Recommendation Report for Planning Permission for Works or Extension to a Dwelling

REF NO: AL/40/25/HH

LOCATION: Jasmine Cottage
4 Dukes Road
Fontwell
BN18 0SP

PROPOSAL: Proposed flat roof rear dormer to replace 3 No. hipped roof dormers.

Drawing Title
Roof Plan
as Proposed

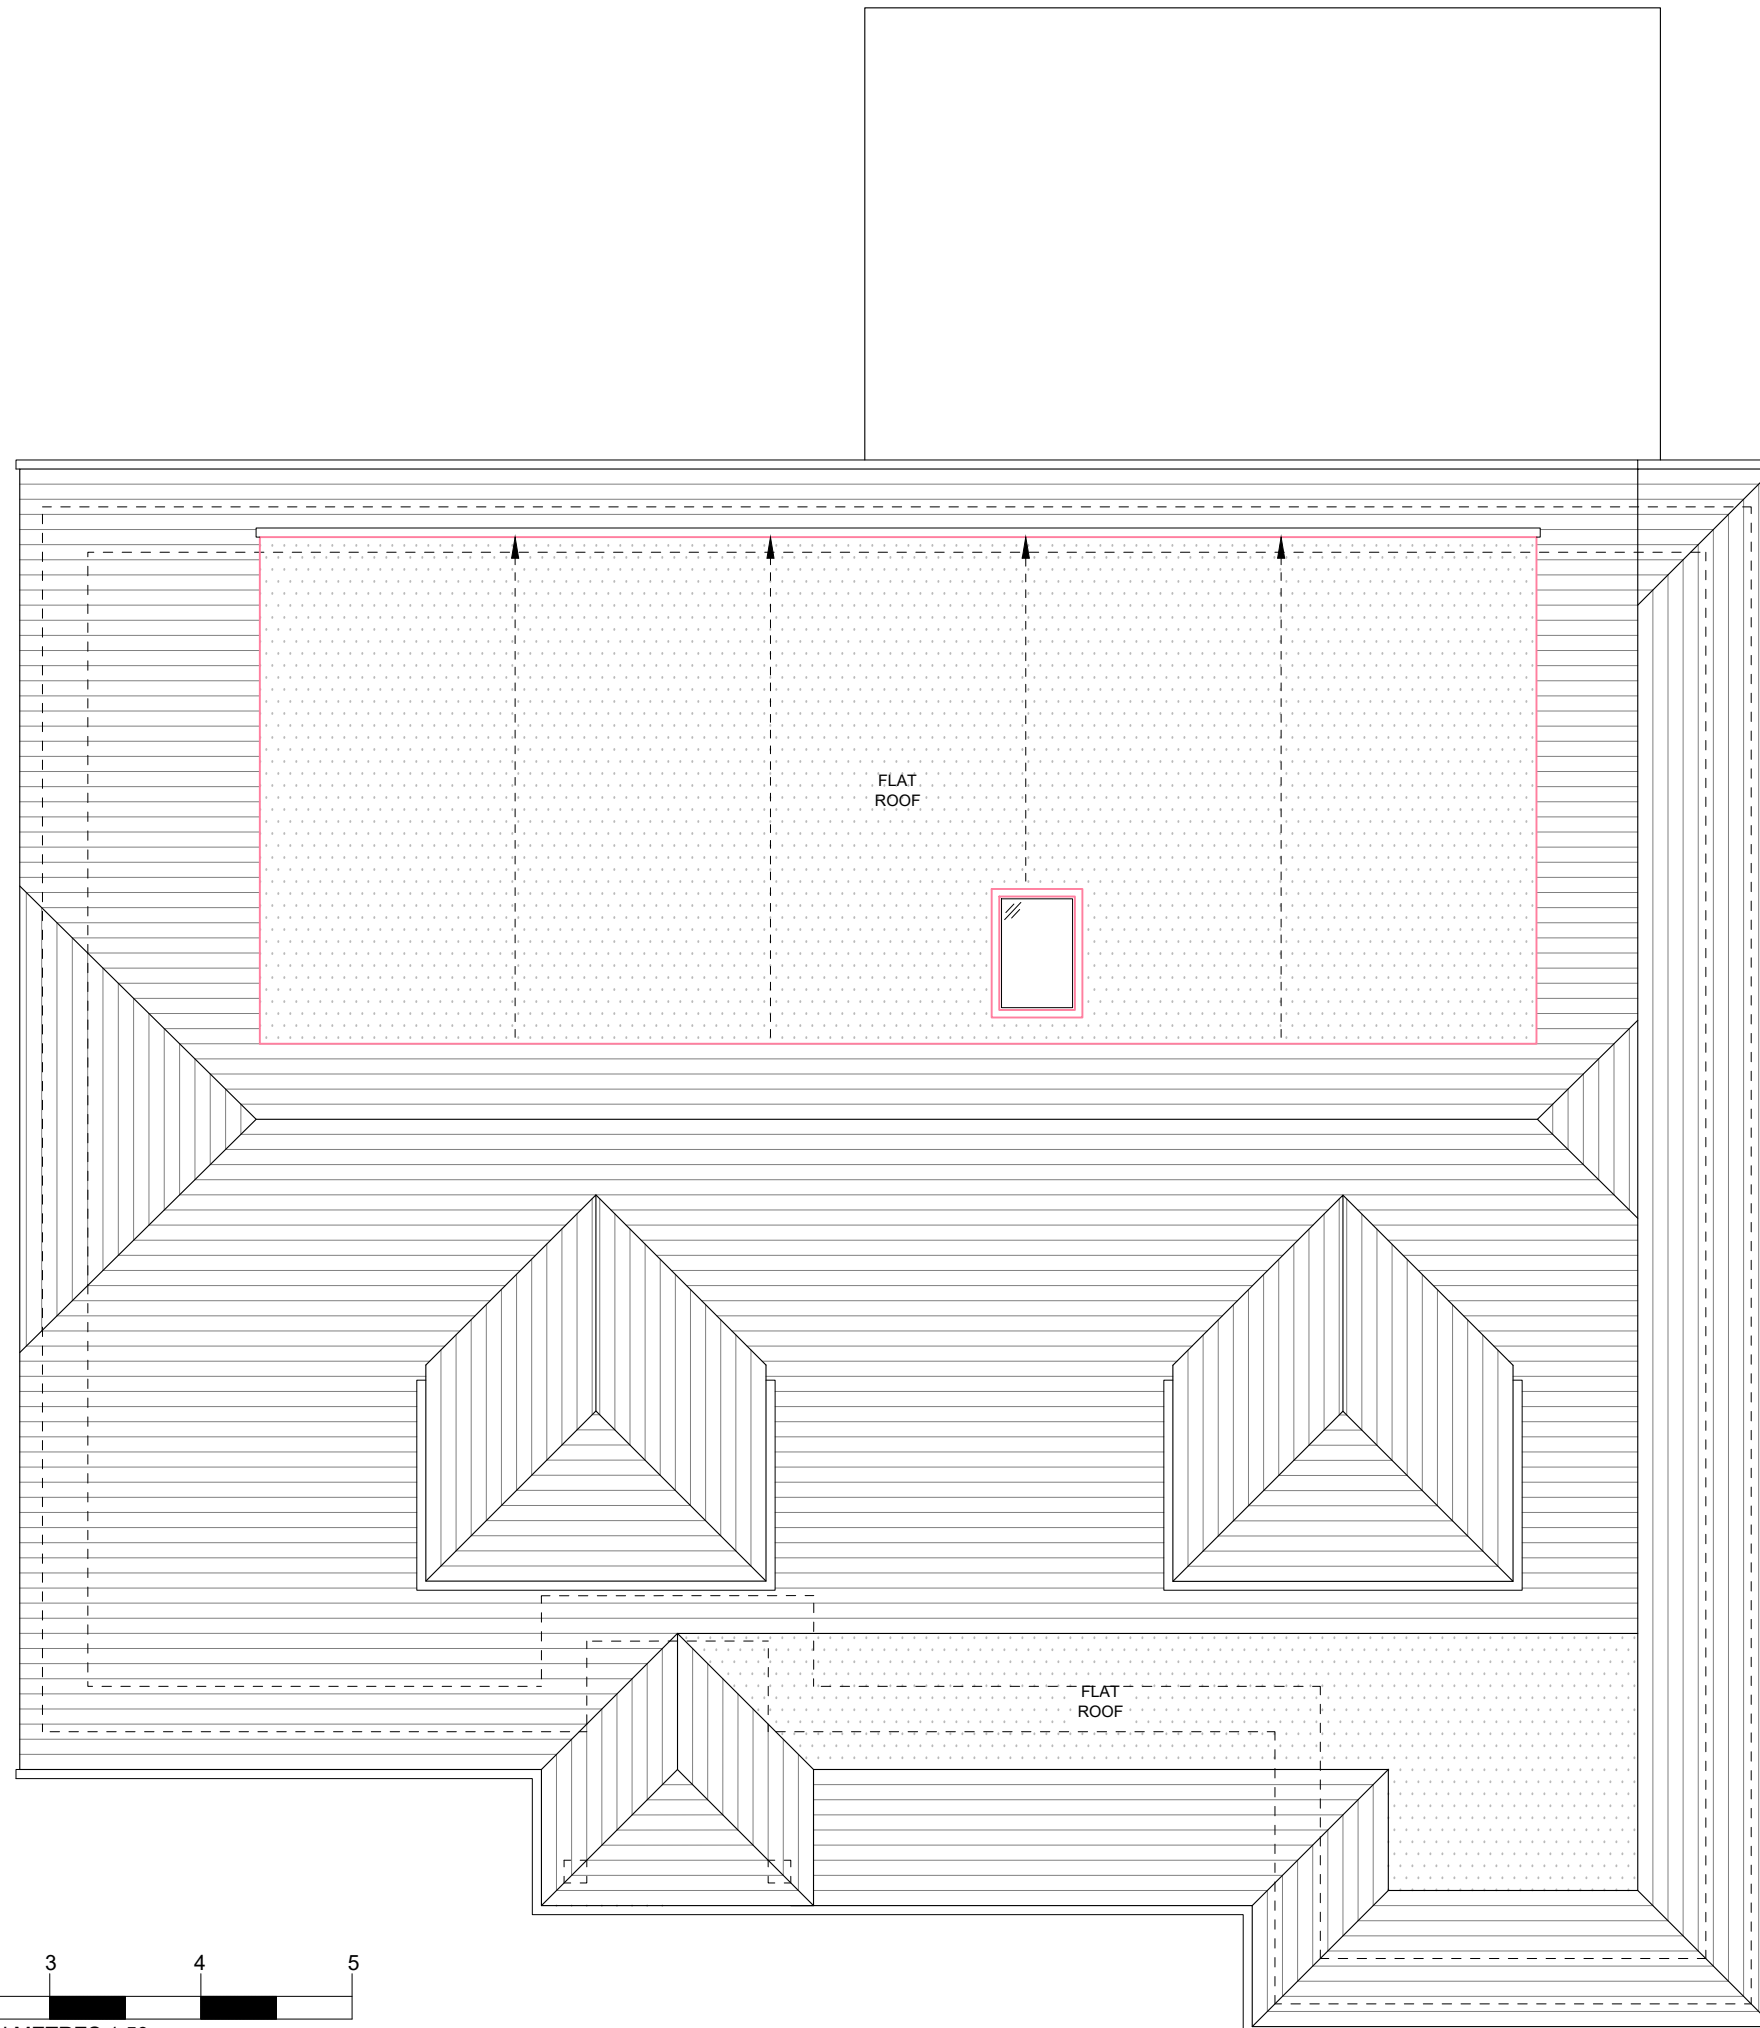
Additionally, 1 rooflight is proposed to the flat roof of the dormer. Due to the siting of the rooflight, it would not give rise to any overlooking concerns.

① ELEVATIONS - AS PROPOSED  
Scale: 1:100

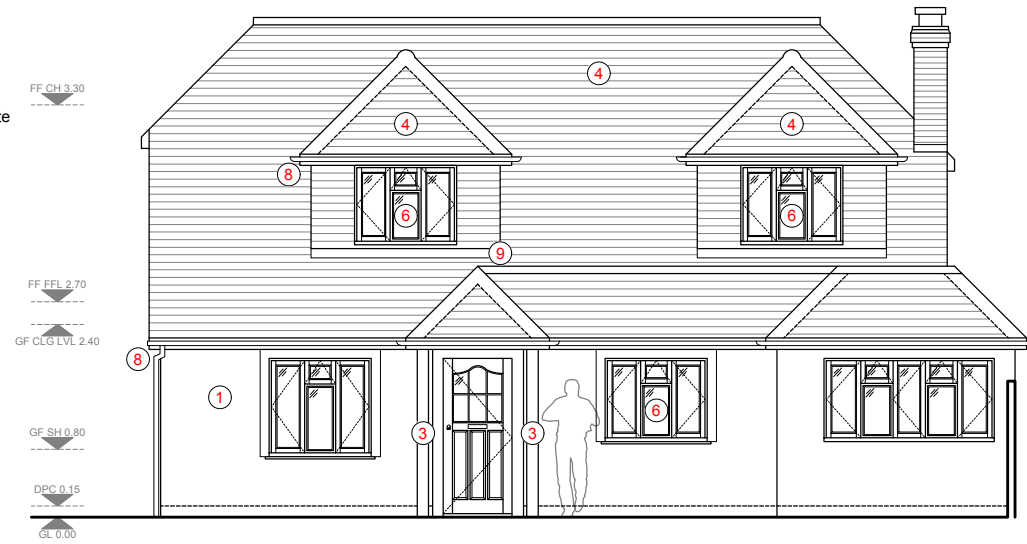
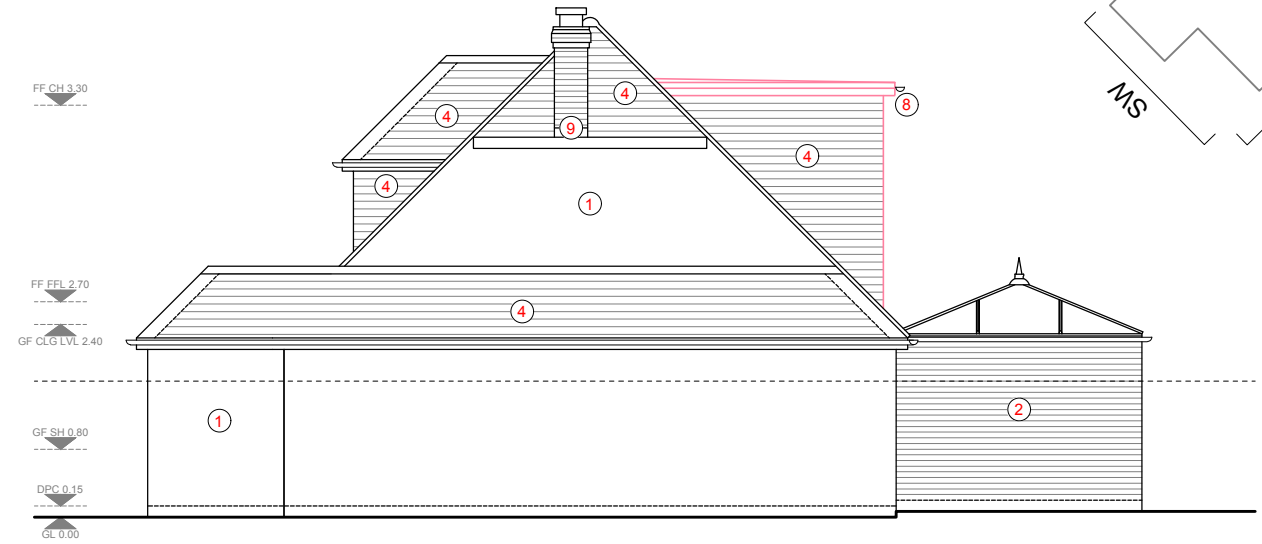
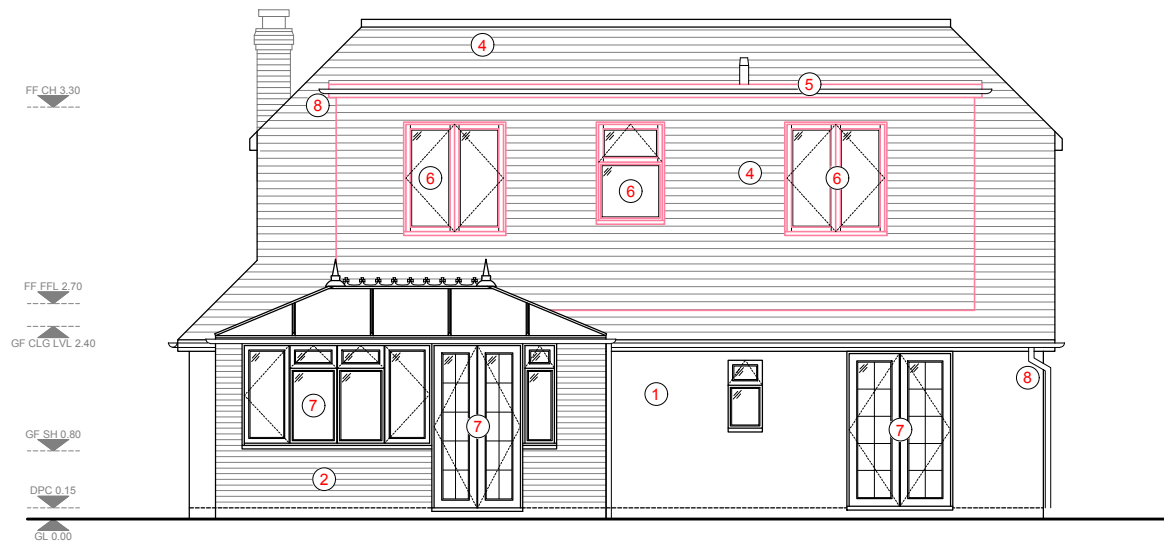
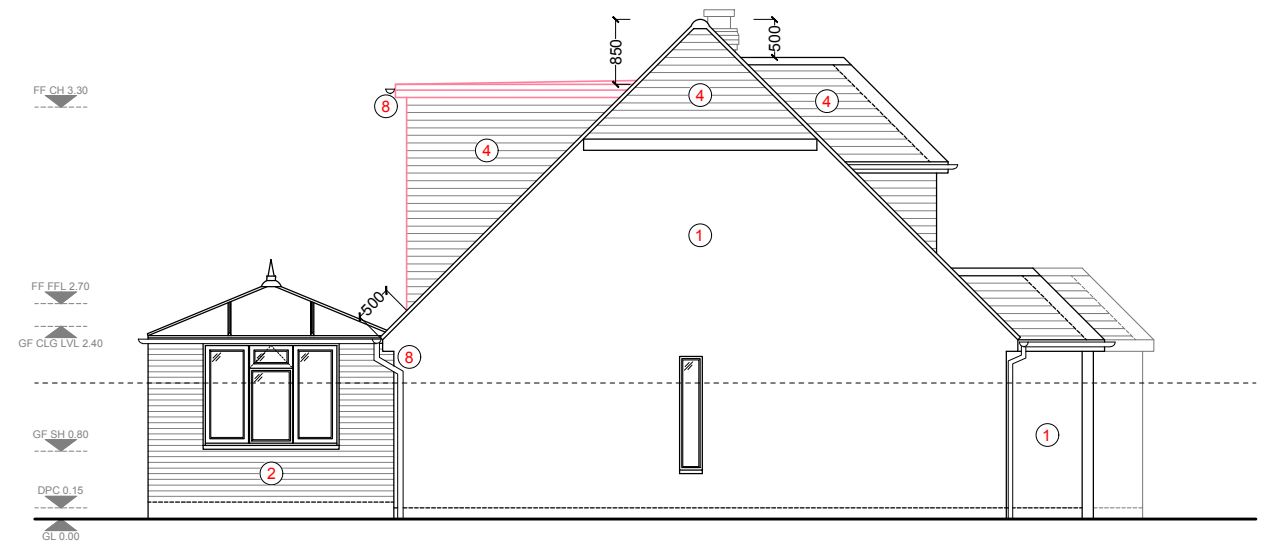
The proposed rear dormer would measure 8.5m wide, 1.5m deep and 3m high. It would be set down 0.8m from the main ridge of the dwelling, and set in 1.1m from the flank elevations. The dormer will be finished with hanging tiles to match existing, and the windows will be white UPVC to match existing. The dormer is in partial conflict with the Arun Design Guide, which states that dormers should be minor incidents on the roof plane and incorporate pitched roofs in most cases, avoiding large box-shaped designs. However, as the dormer is to the rear of the property thus will not be visible from the public realm and is similar to that which could be constructed under permitted development. As such, the proposed rear dormer is acceptable in this instance.

The proposed rear dormer would maintain 3 windows which would be sited in similar positions to those existing. The overlooking effects across neighbouring properties would be similar to the level already experienced by nearby occupants and the proposal would not result in increased overlooking. The dormer is contained within the footprint of the existing building, therefore the proposal would not result in overbearing or overshadowing effects.
